Our Ref: BR/199/19/PL
Your Ref:

Town & Country Planning Act 1990 (as amended)
Town and Country Planning (Development Management Procedure) (England) Order 2015
Application for Full Planning Permission

Development Conversion of existing Health Centre (D1 non-residential institution) unit to 4 No. studio flats. This application may affect the setting of a listed building.
Location Clock Walk 7 High Street Bognor Regis

02 Site Block Plan
Scale:1:500

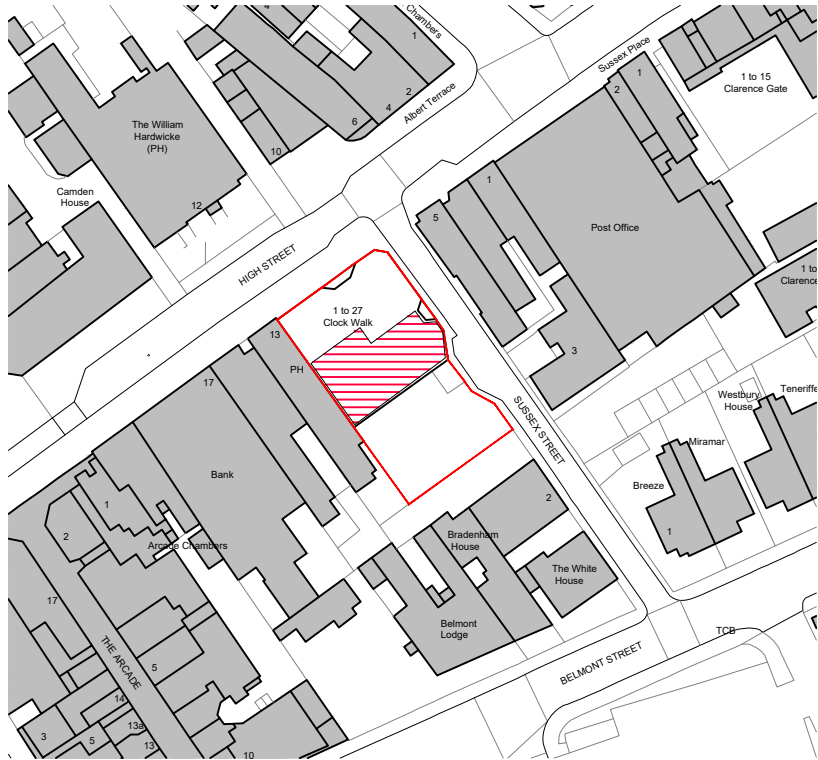
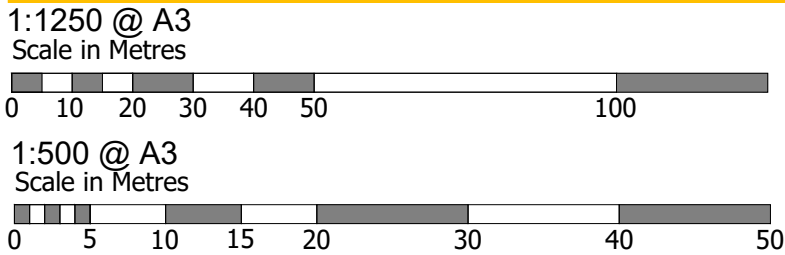
Block Plan Amend

Please clearly highlight/hatch only the proposal.
